# Rezoning Transportation Analysis

Petition Number: 2023-036

| Revision Log: | Date     | Description        |
|               | 10-26-23 | Second Review (TM) |

**RZ-2**

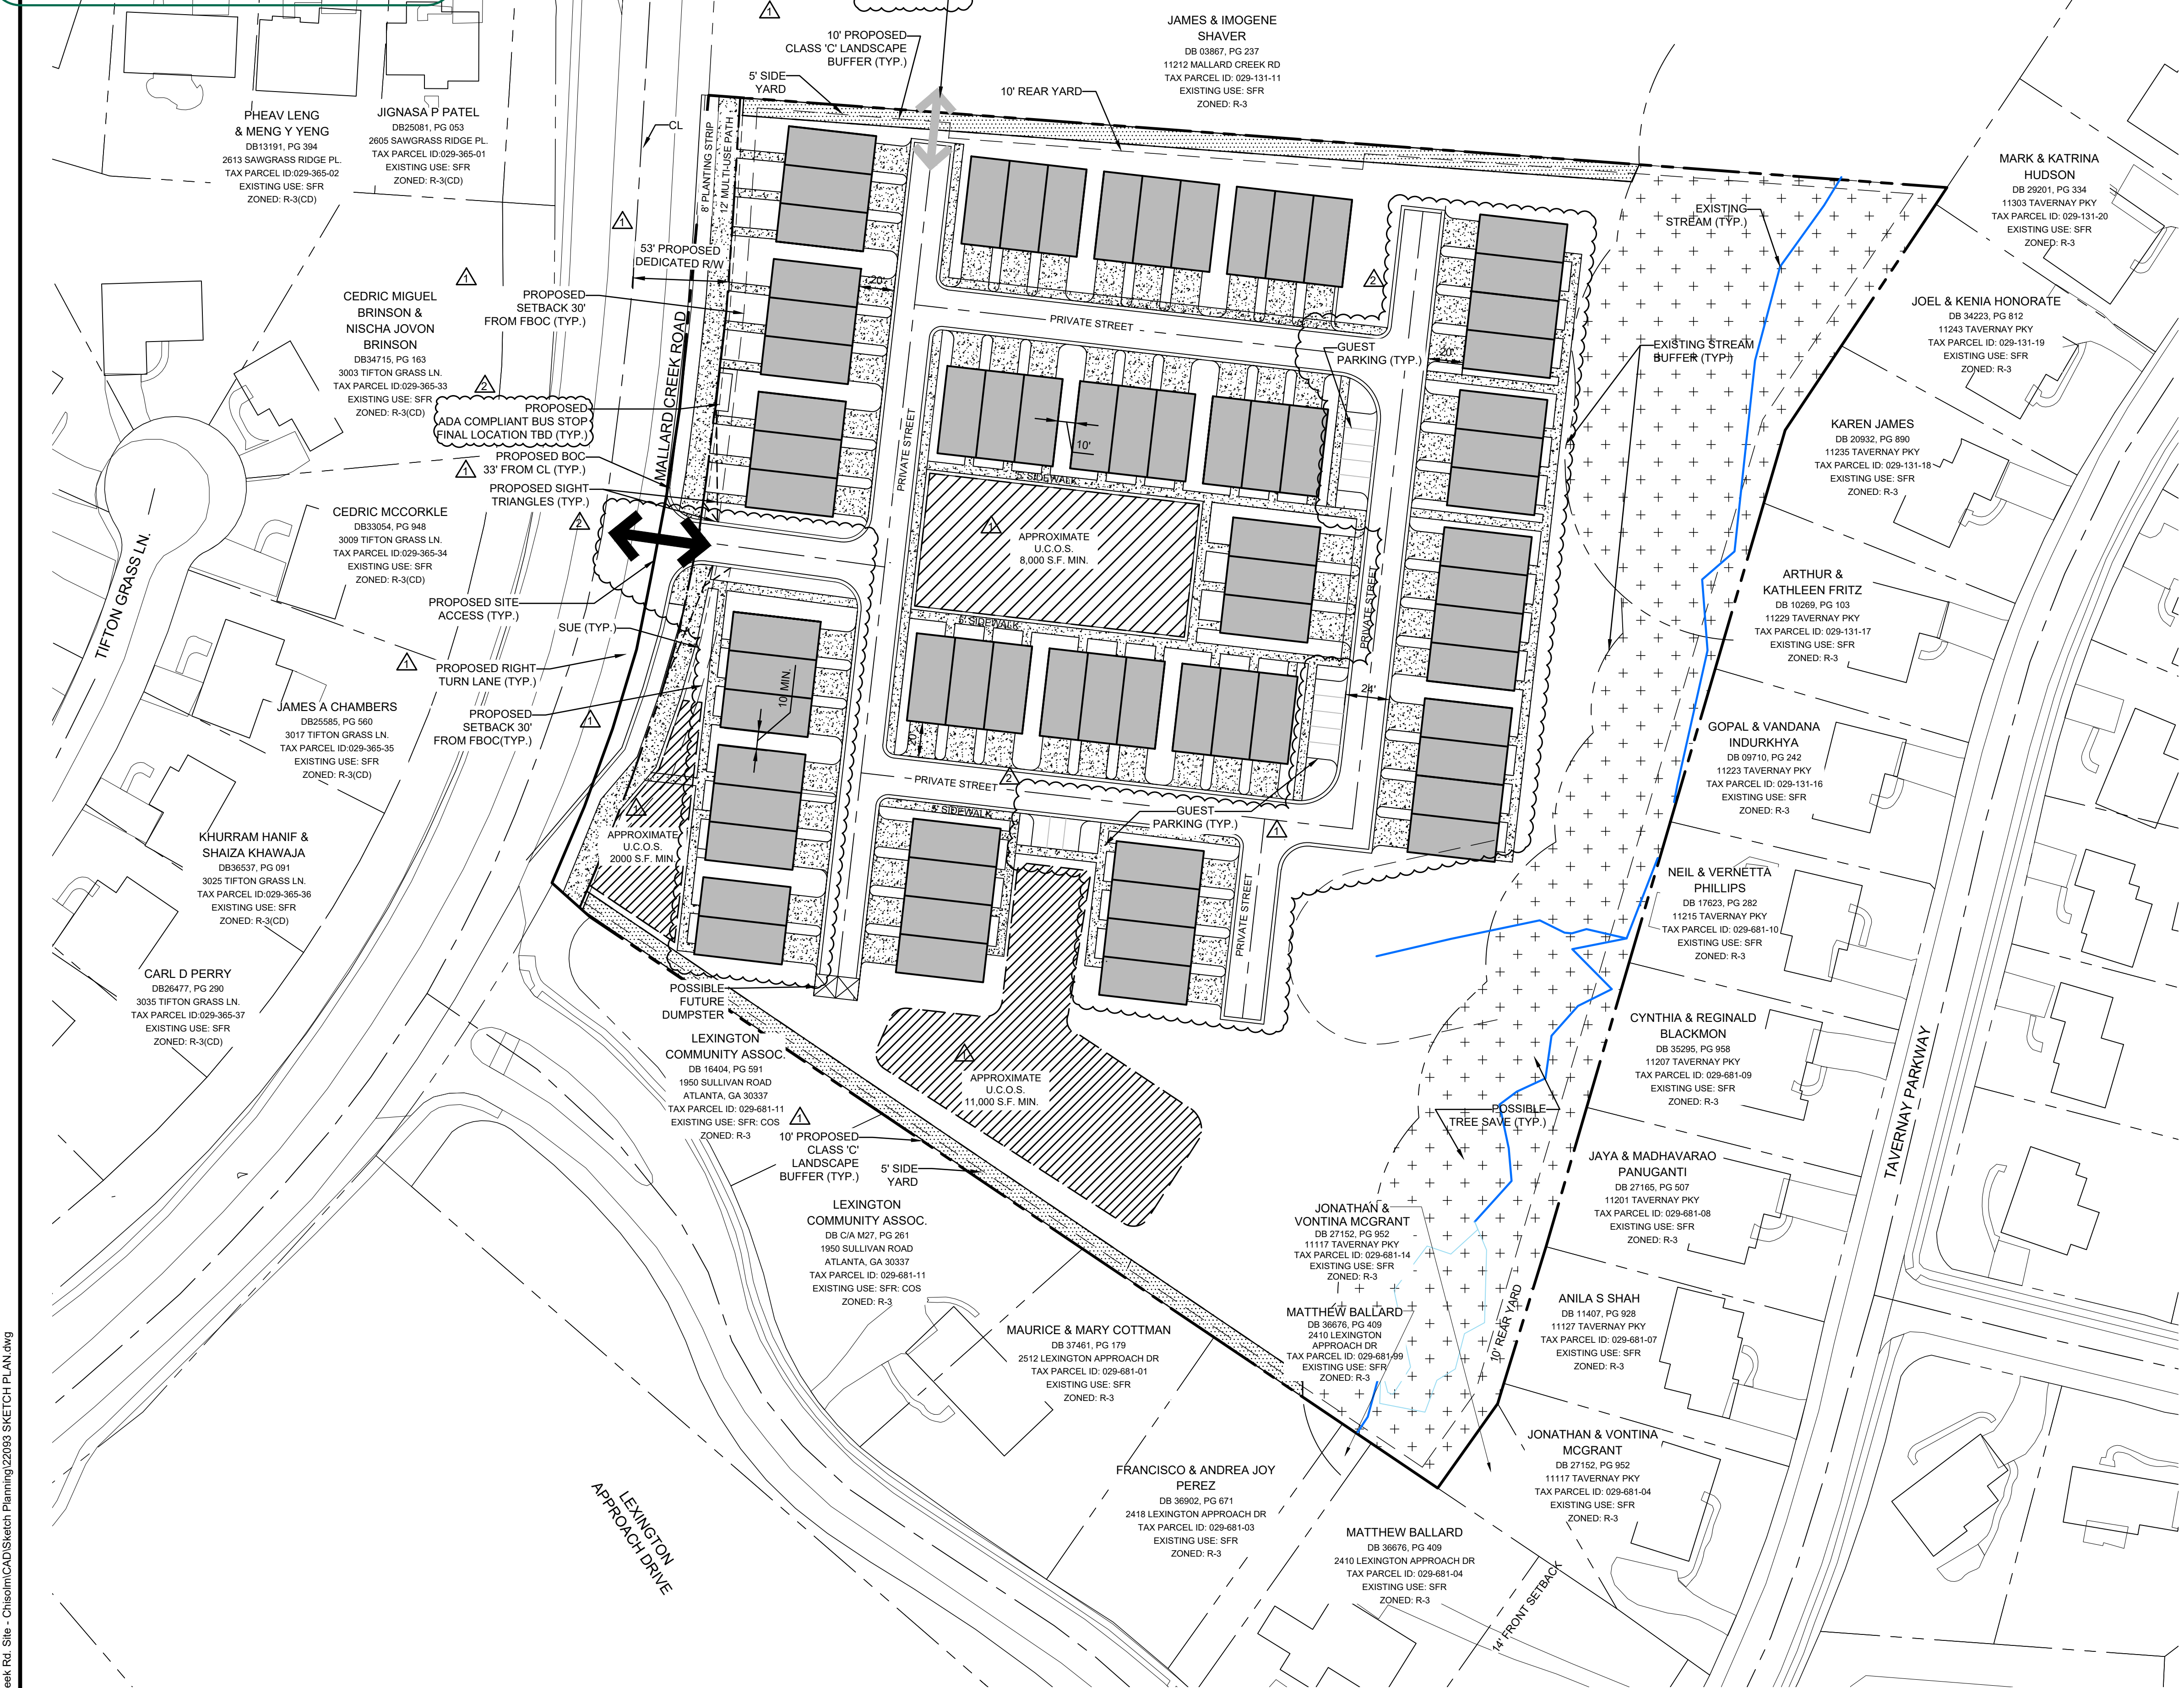
- a. ~~**Mallard Creek Road:** Location of curb and gutter to be coordinated with NCDOT STIP U-6028 to accommodate the STIP project along with Charlotte Streets Map with a roadway typical section of 4+ Boulevard with a Shared Use Path.~~

~~Label and dimension the curb and gutter from the centerline for each road on the site plan.~~

4. ~~Revise site plan and conditional note(s) to commit to coordinating with NCDOT regarding STIP U-6028. Site plan shall show U-6028 on the rezoning plan.~~

5. ~~Revise site plan and conditional note(s) to commit to constructing a dedicated right turn lane into the site with 100 feet of storage in coordination with NCDOT.~~
